**KIRKLEES METROPOLITAN COUNCIL
INVESTMENT & REGENERATION SERVICE**

DELEGATED DECISION TO DETERMINE PLANNING APPLICATIONS

Reference No:	2022/62/93930/W
Site Address:	1, Huntsman's Close, Beaumont Park, Huddersfield, HD4 7BR
Description:	Erection of single storey rear and front extensions and mono pitched roof above garage, formation of balcony to rear, application of off-white render insulation cladding to all elevations and external alterations
Recommending Officer:	Luke Walstow

OFFICER REPORT

DRAWING No.
P102

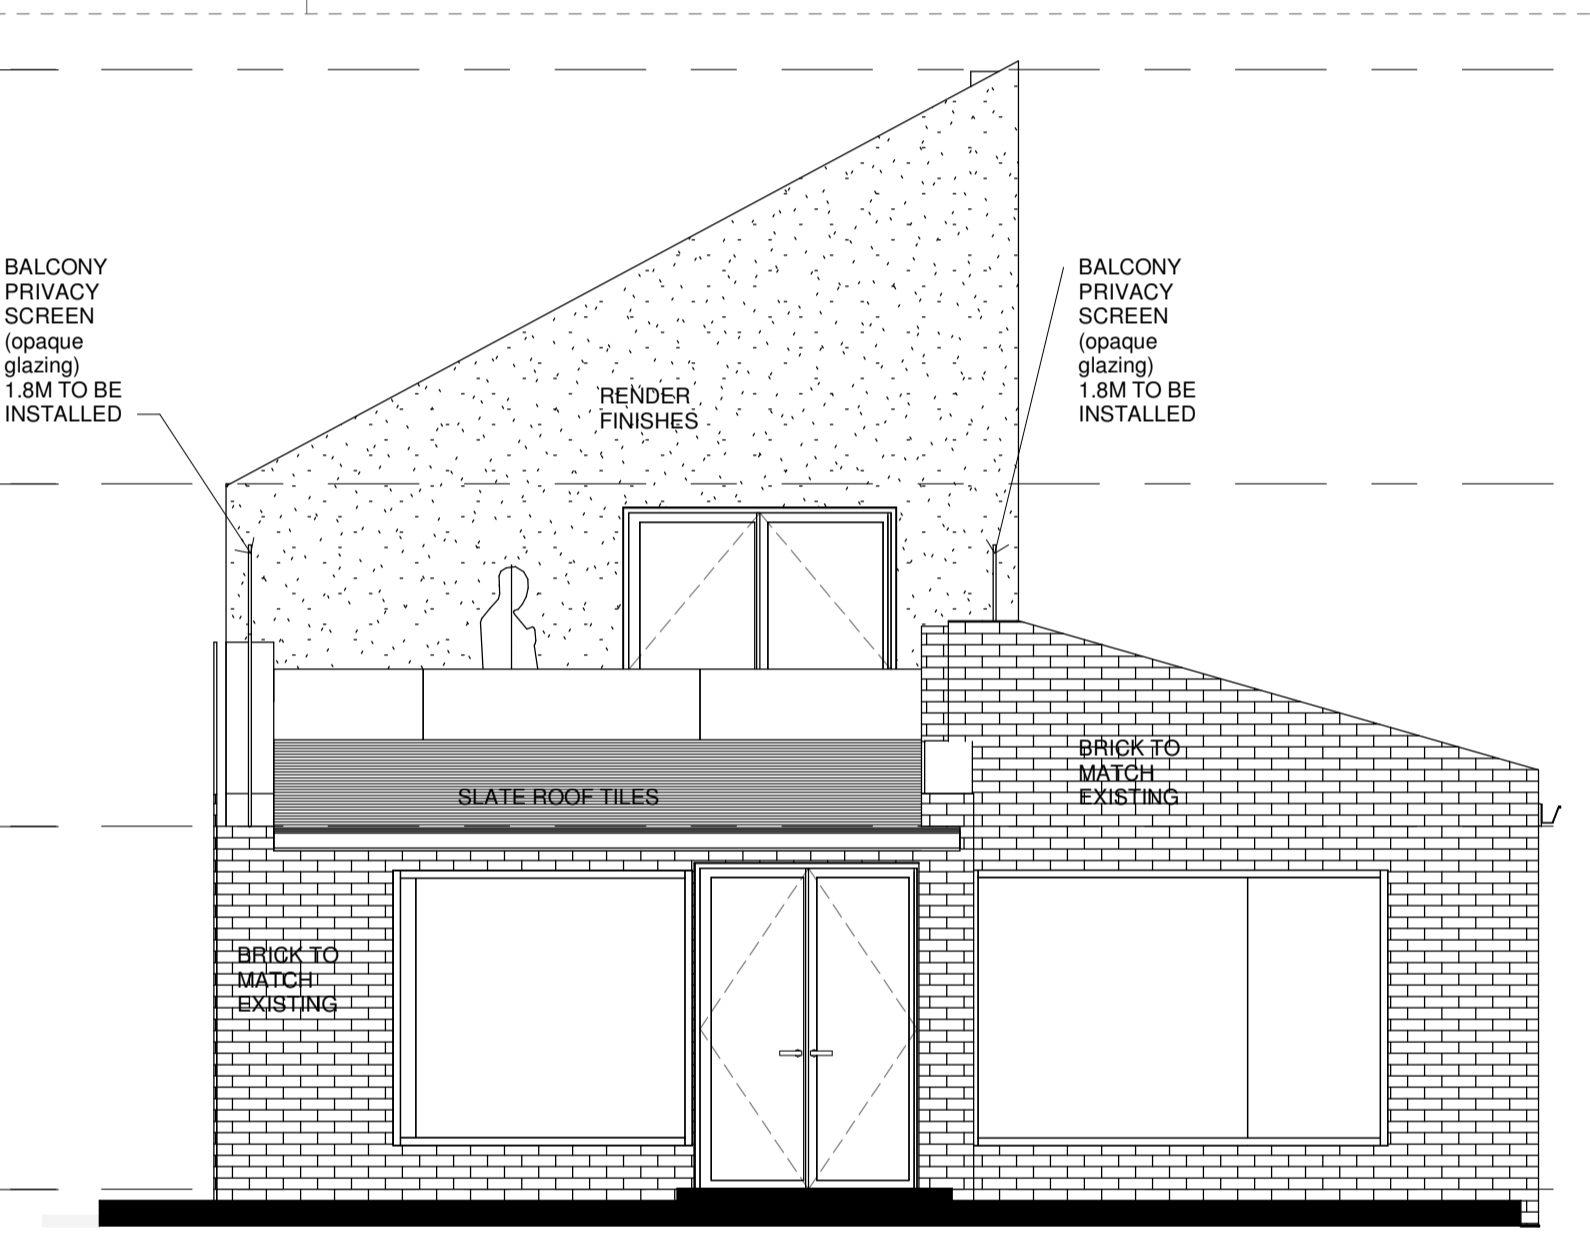
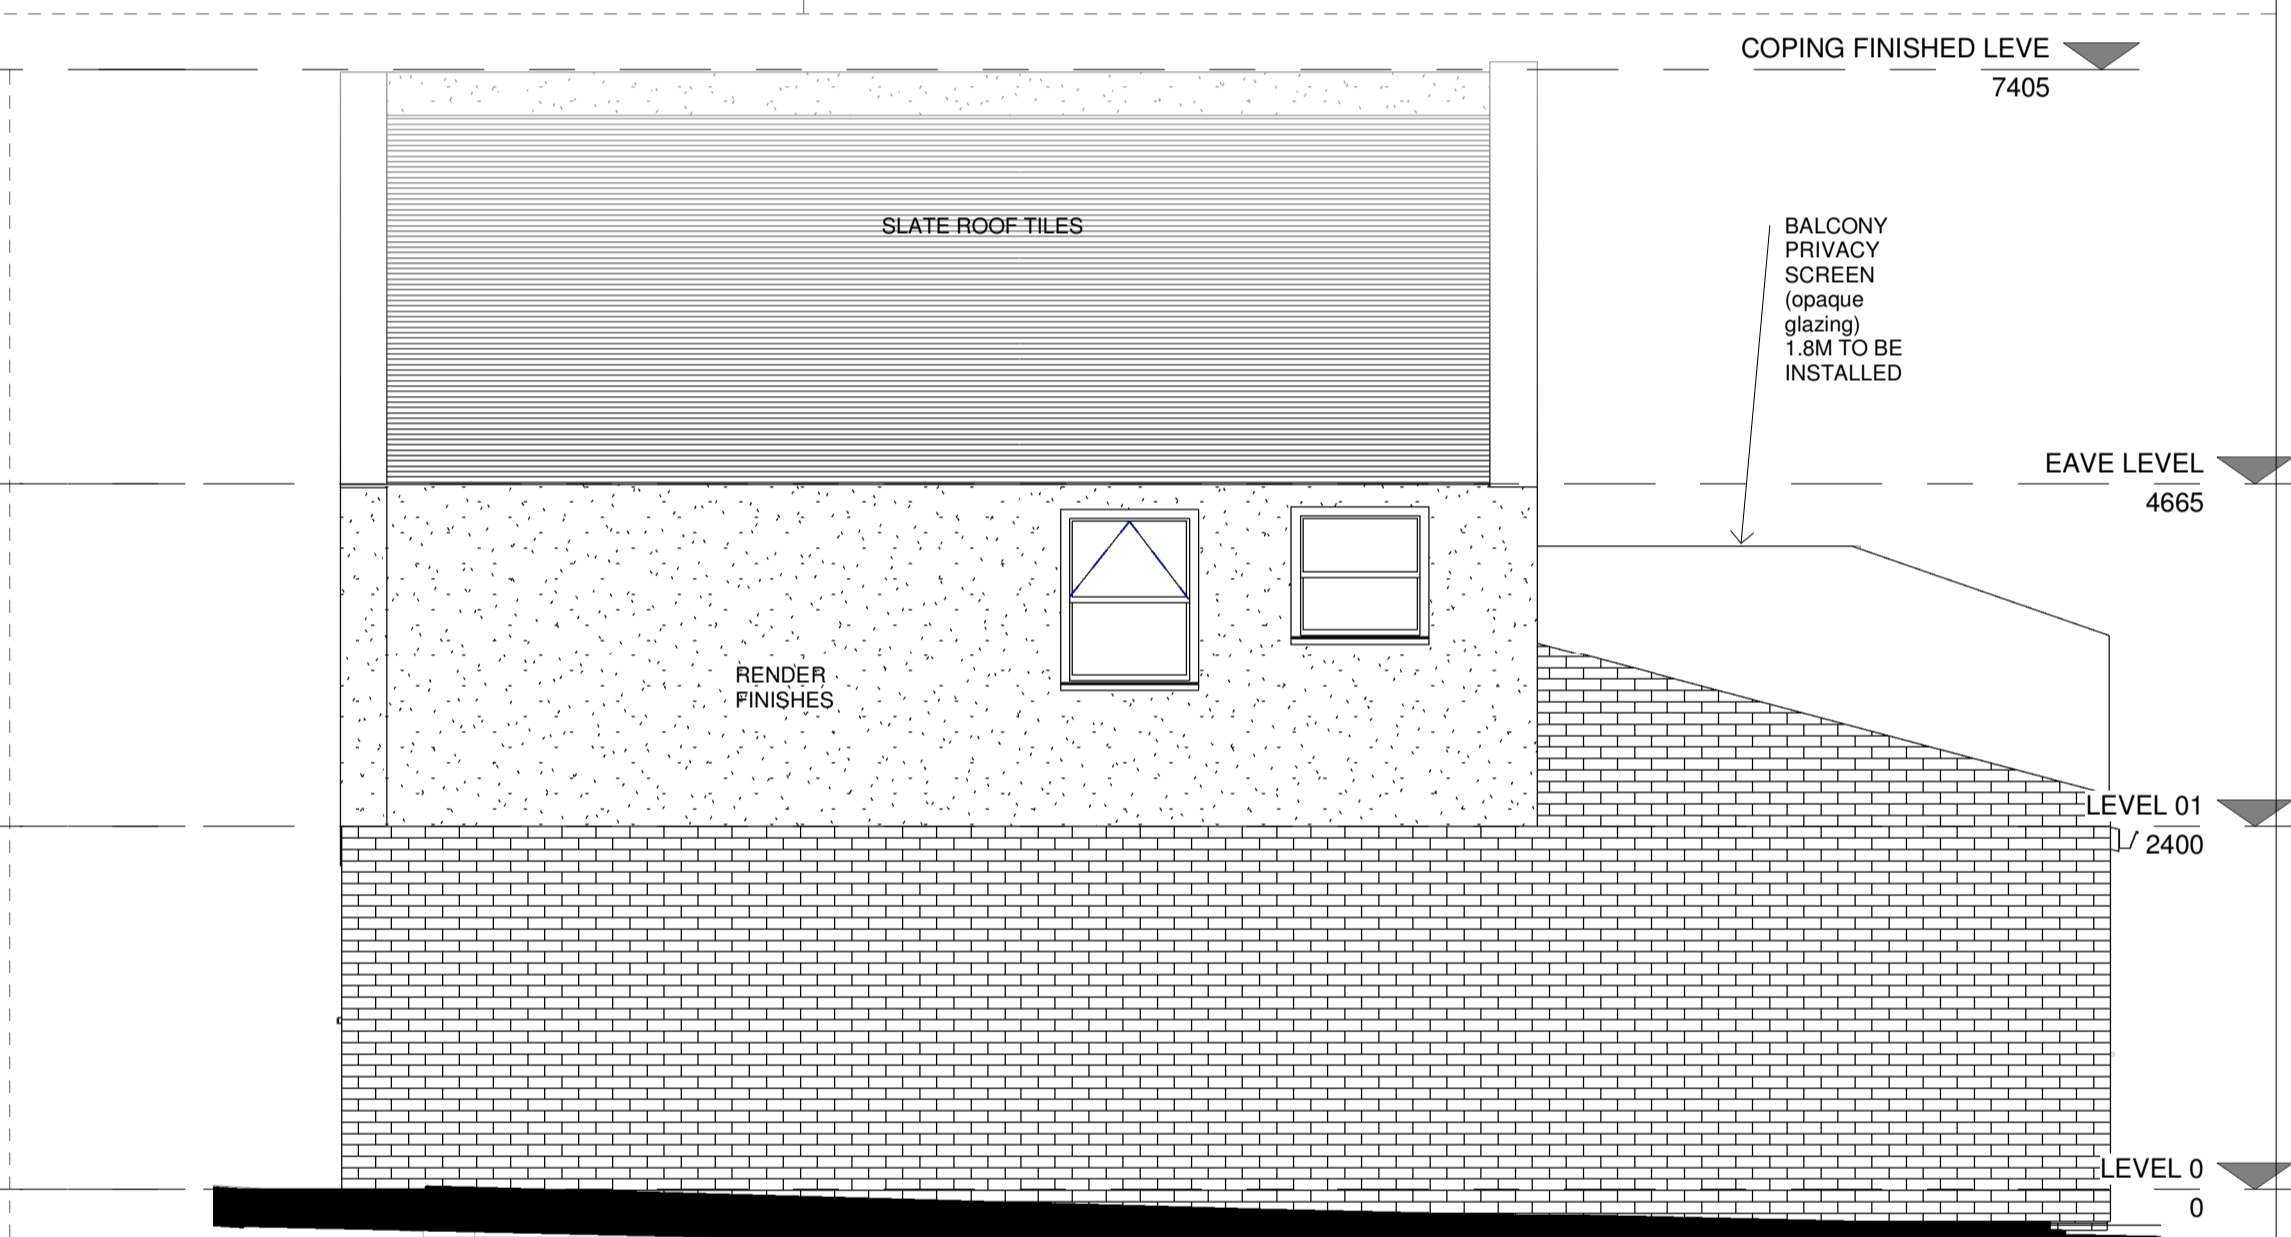
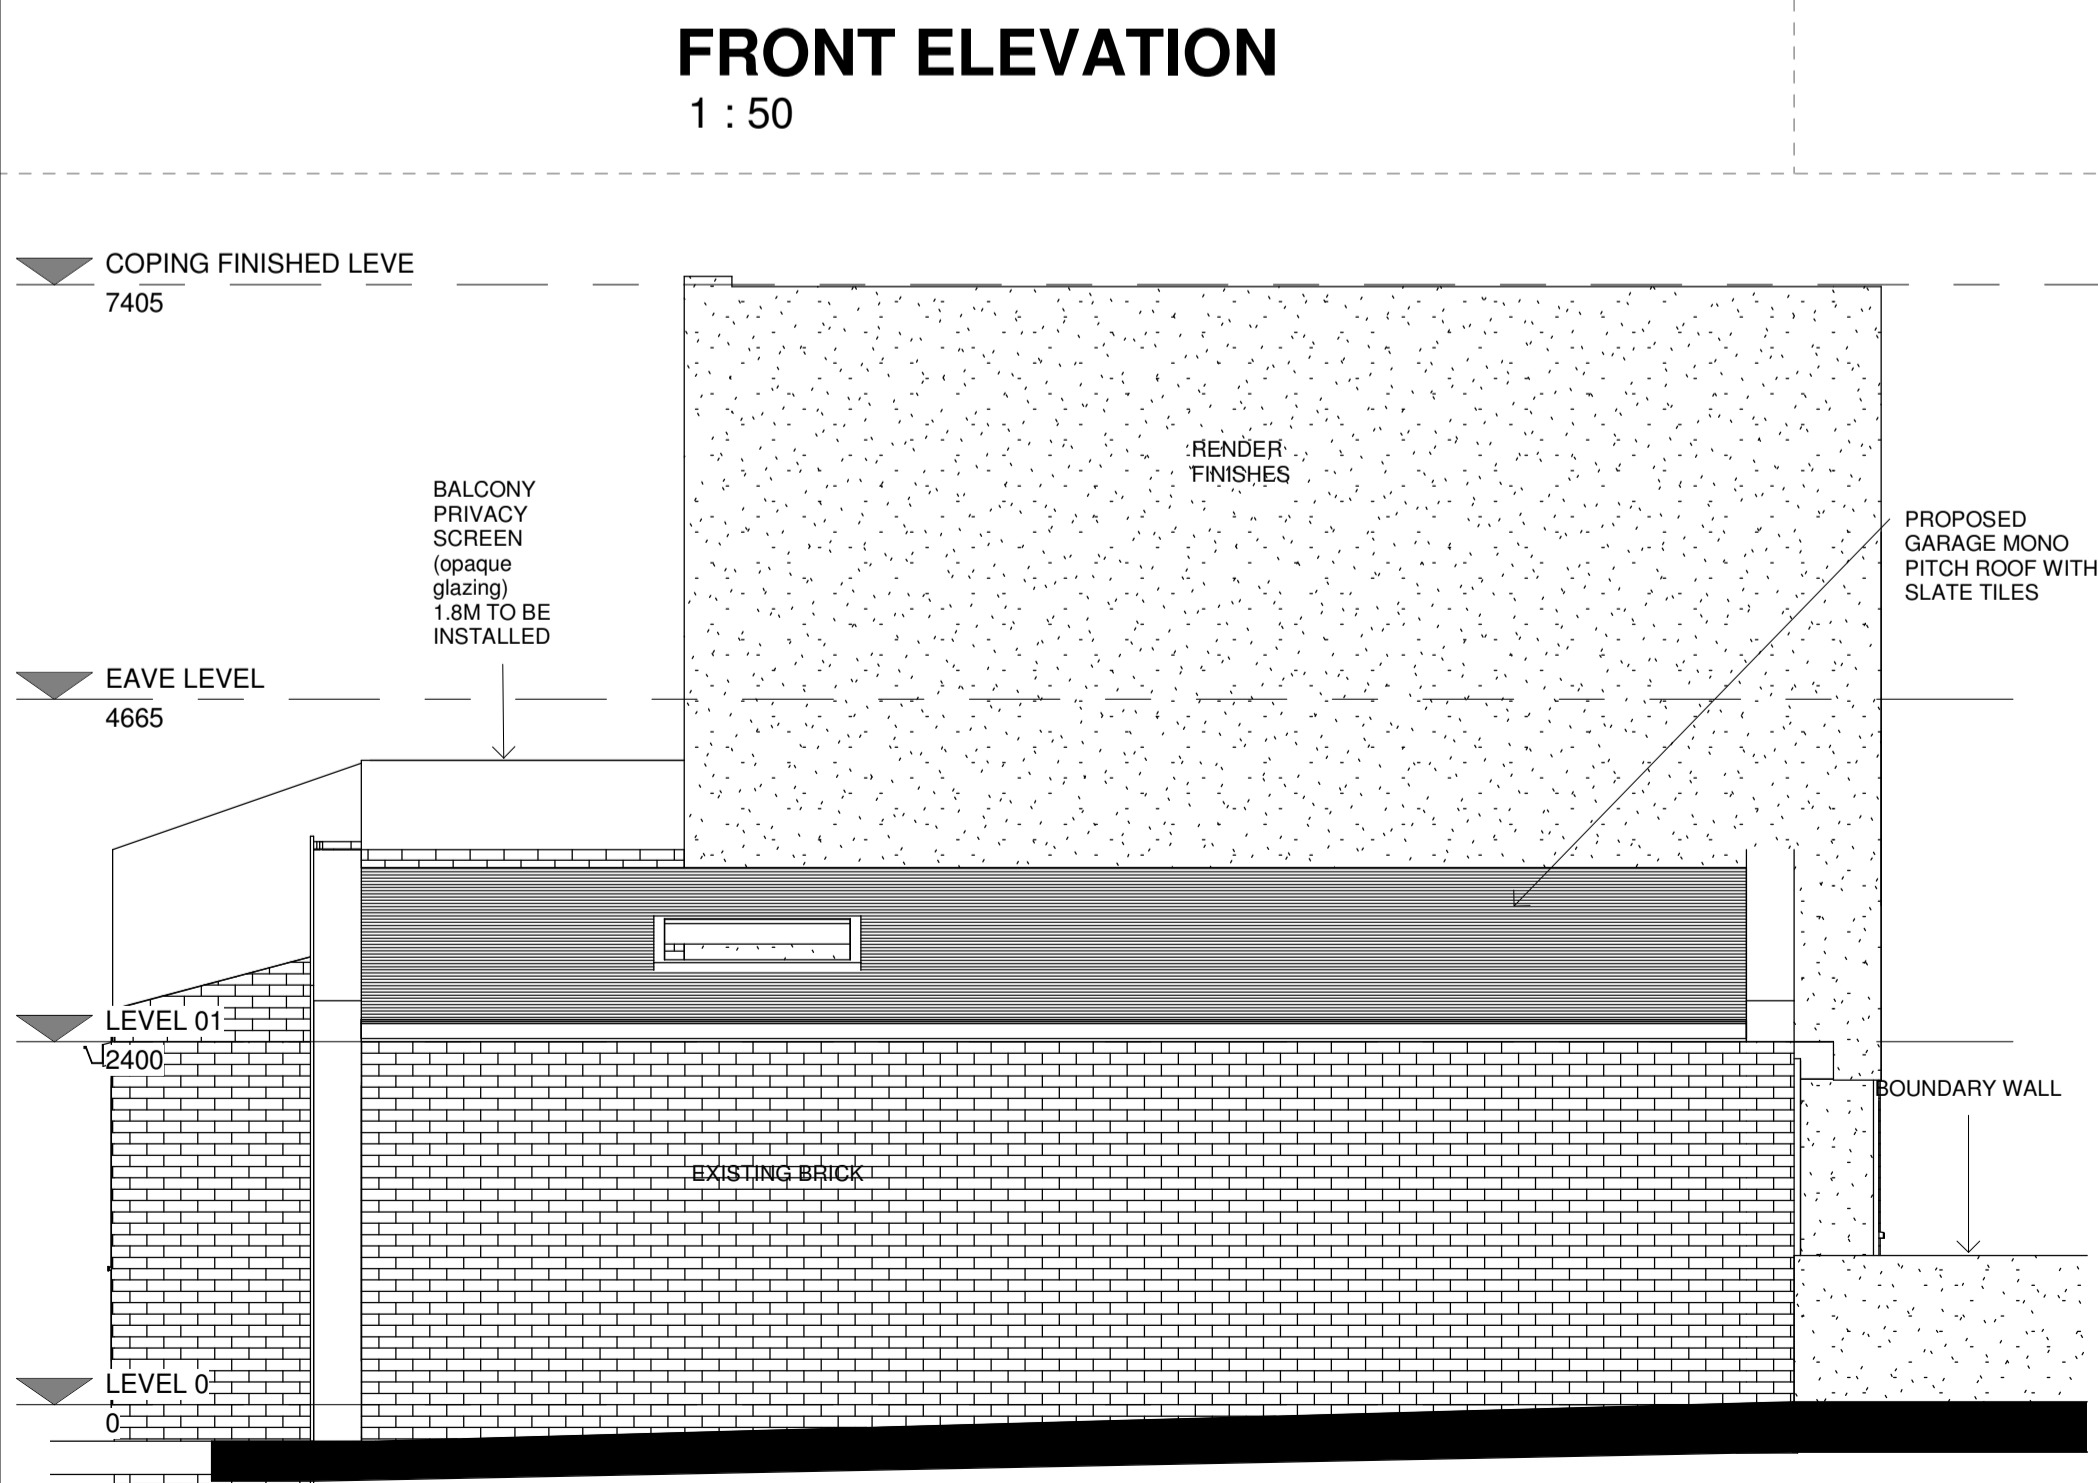
The balcony proposed will be located above the proposed rear extension, with access gained through one of the dwellings. The balcony will have views of the rear garden. Proposed 1.8m opaque screens are proposed to be installed on either side of the balcony to limit potential overlooking of neighbours' homes and gardens. In terms of design, the balcony is deemed acceptable by officers.

3 Huntsman's Close is the neighbouring property located to the South of the site. Concerns were raised by officers in relation to the balcony and overlooking of this property and private amenity space. Within amended plans submitted, the balcony has incorporated 1.8m high privacy screens on each side of the balcony made from opaque glass. This would limit the viewpoint from the balcony to an acceptable level in this case.

4. The development shall not be brought into use until the privacy screens detailed upon drawing P102RevP2 have been installed. The privacy screens shall be thereafter retained.
